September 22, 2015

Re: Reason for Request – Multi-Specialty Clinic
Requesting review and approval of Site Development Plan for Building Permit
Legal description: TR 2 PLAT OF TRS 1 & 2 CAPSTONE SUBD CONT 8.355 AC
City Planning Project #1009090

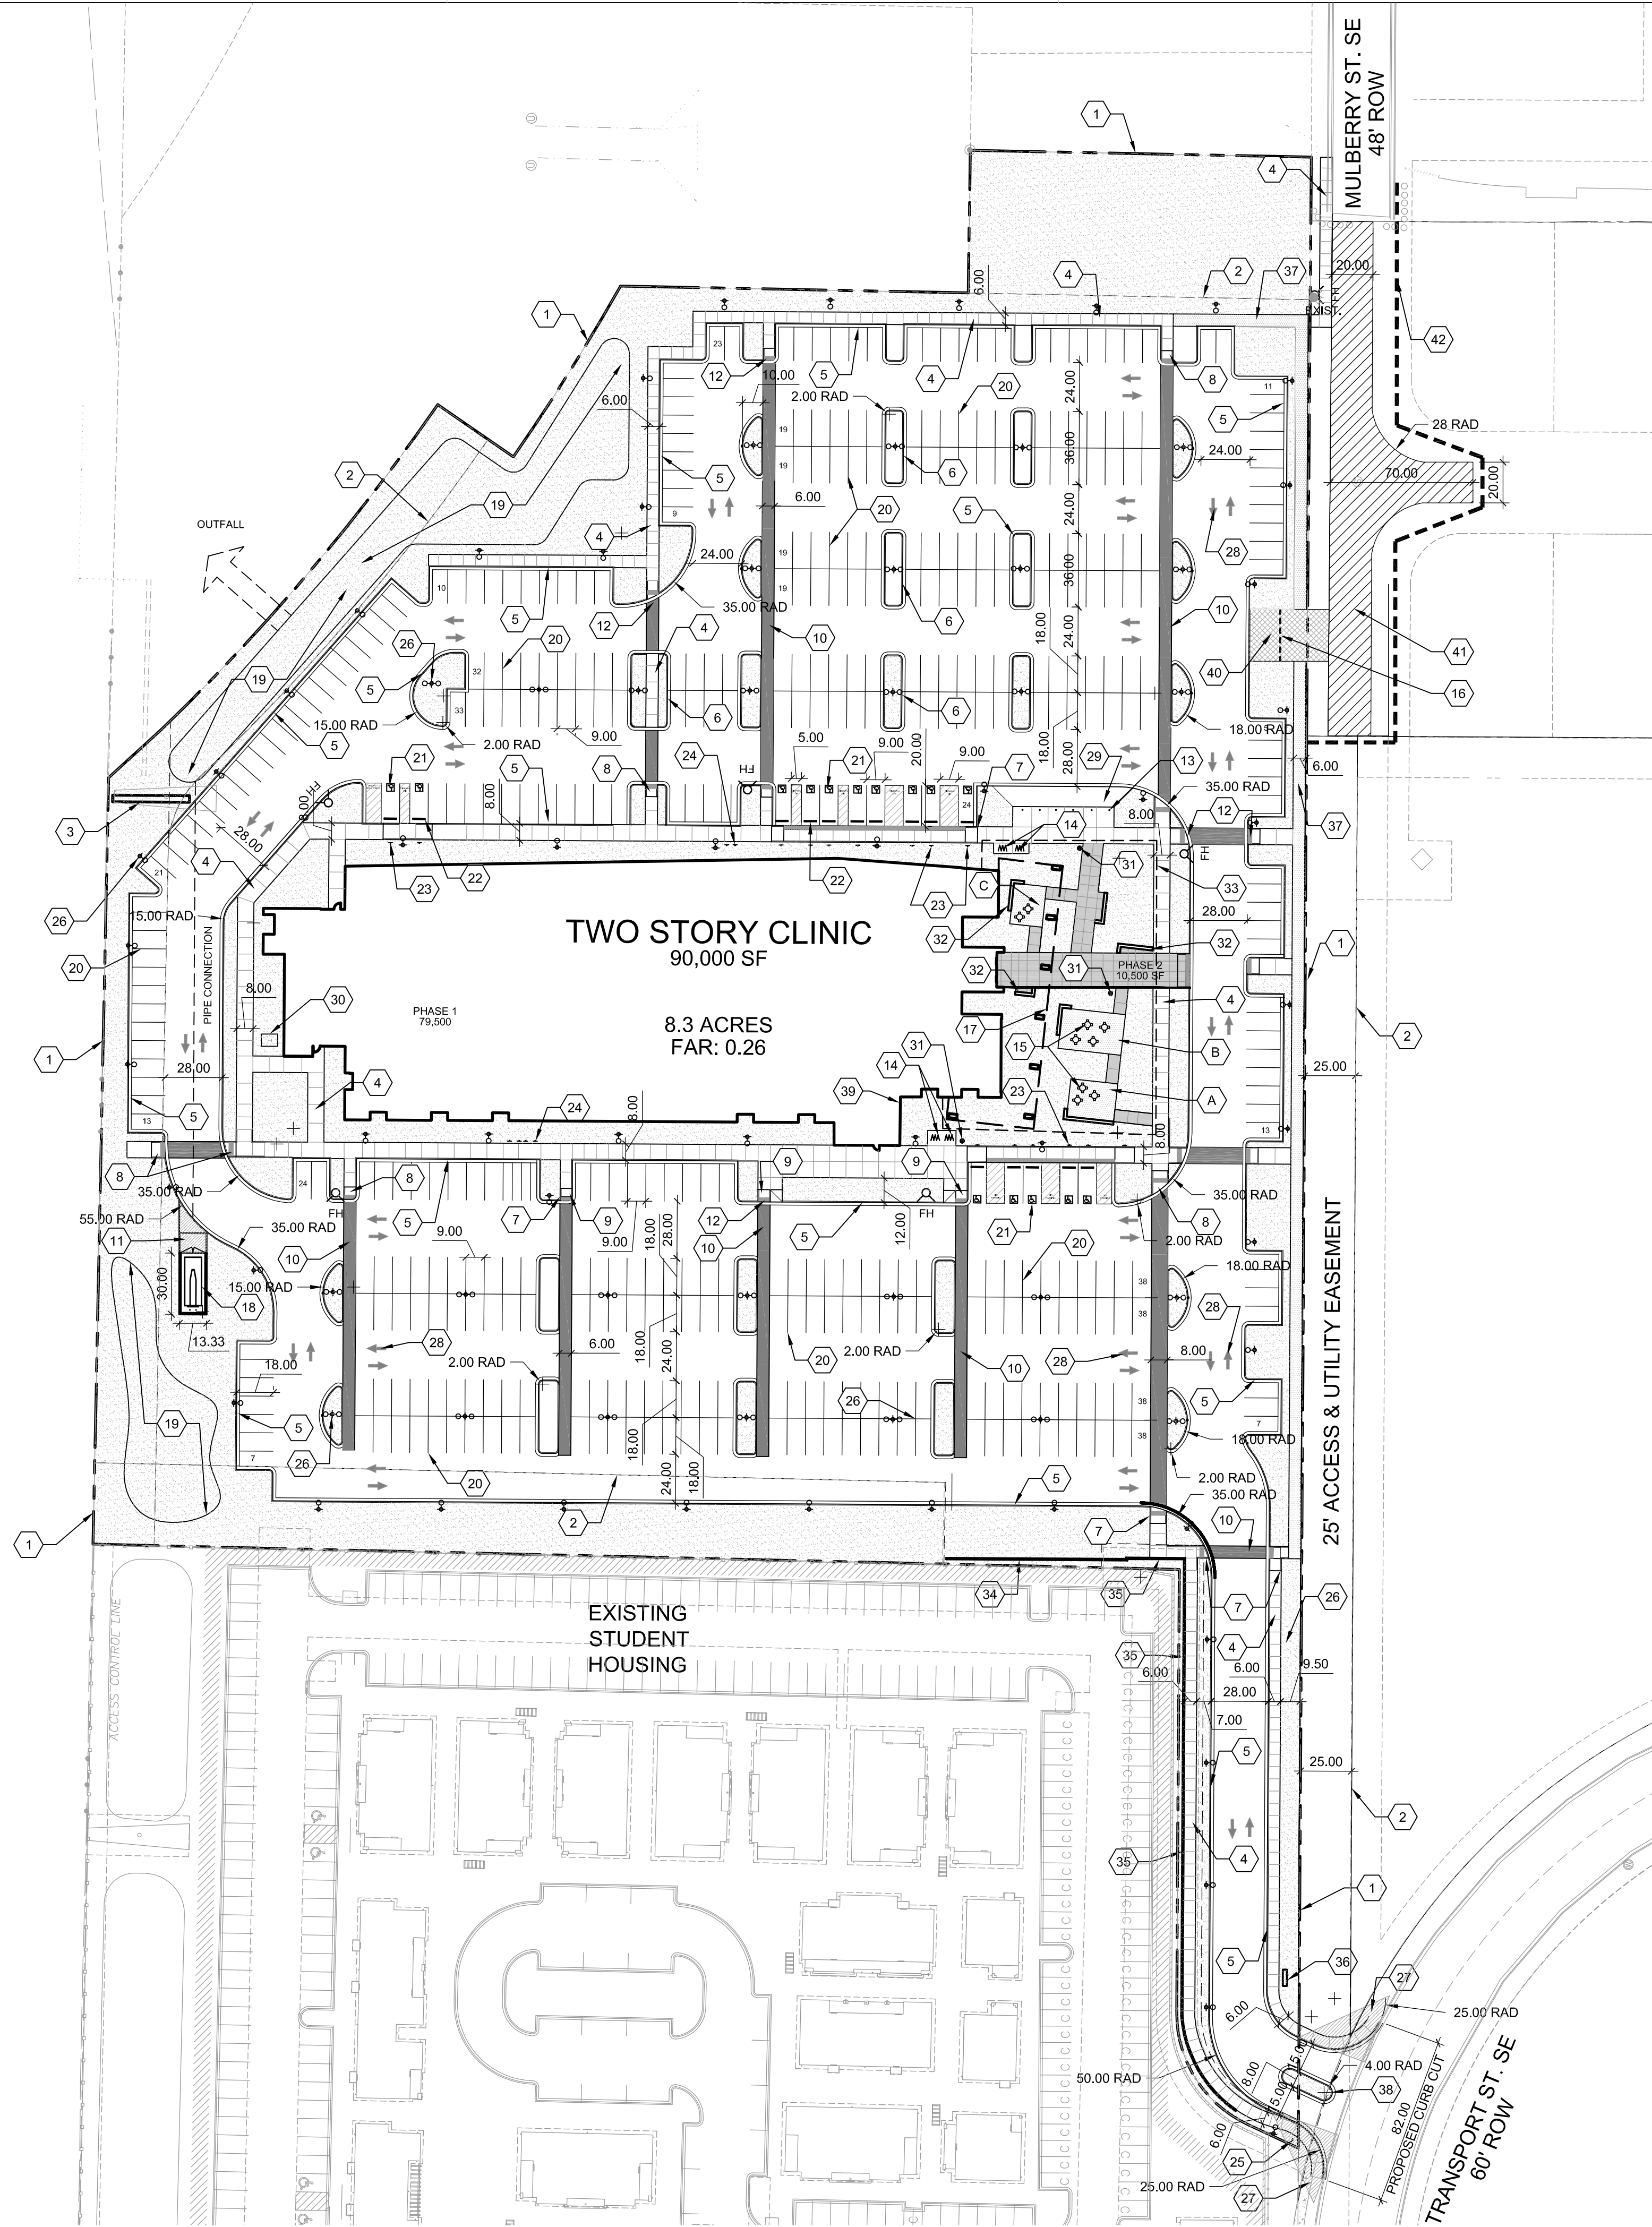
D. The Site Development Plan for Building Permit shall be amended to reflect the 16' light pole height restriction per section 14-16-3-9 (Area Lighting Regulations) of the Zoning Code.

G. The final design of the proposed emergency access drive from the subject site to Mulberry St. (included as Keyed Note 40 on sheet SDP 1.1) shall be reviewed and approved by the Fire Department/Fire Marshal prior to DRB review of the Site Development Plan for Building Permit for the proposed healthcare clinic.

- a. The site plan has been updated to reflect the light pole limitation with the spacing revised accordingly

- a. D/P/S met with the Fire Marshal's office on 9/17/2015 to review this item. Fire Marshal comments have been integrated into the design. There were a few changes made to the drive radii which resulted in a few parking spaces being lost.

**LANDSCAPE PLAN**

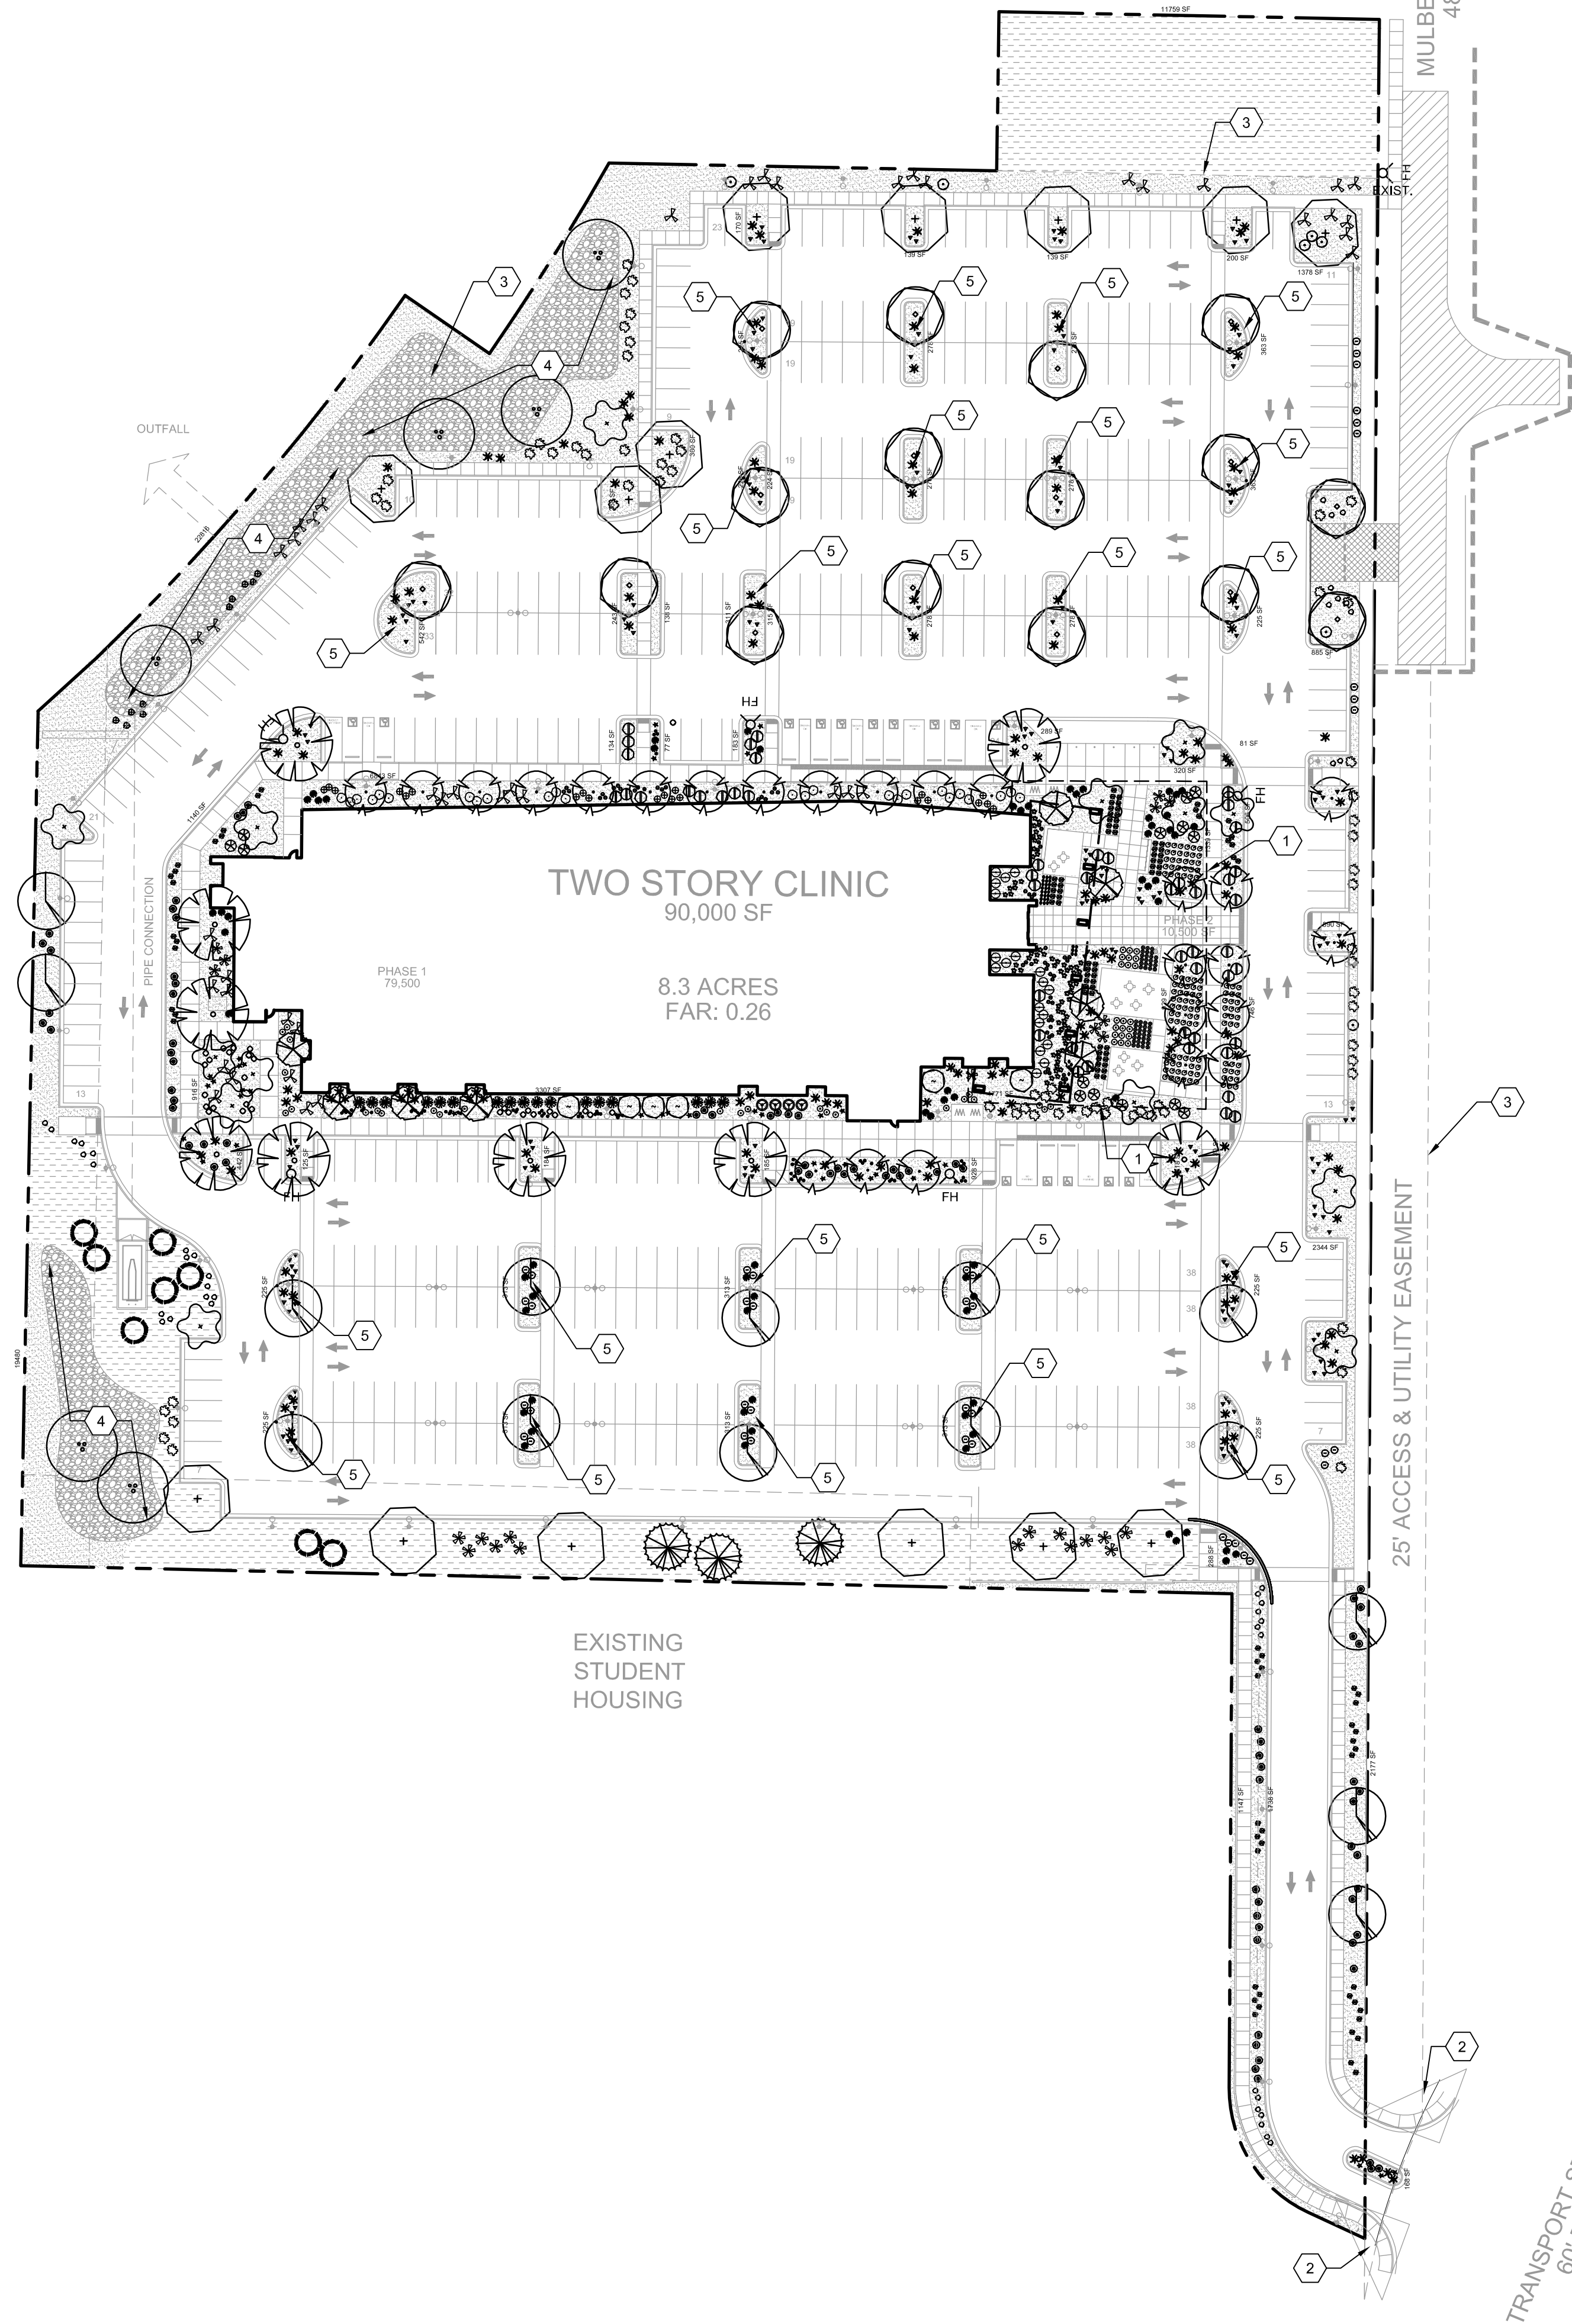
E. The Landscaping Plan shall be amended to indicate whether the proposed plants and species listed on the Plant Legend on sheet SDP 2.1 will be low, medium or high water plants.

F. The Landscaping Calculations section of the Landscaping Plan on sheet SDP 2.1 shall be amended to quantify the total amount of live vegetative coverage to demonstrate that the landscaping plan meets the 75% live ground coverage requirements of the Zoning Code.

- a. The Landscaping Plan has been amended to include this information

- a. The Landscaping Plan has been amended to include this information
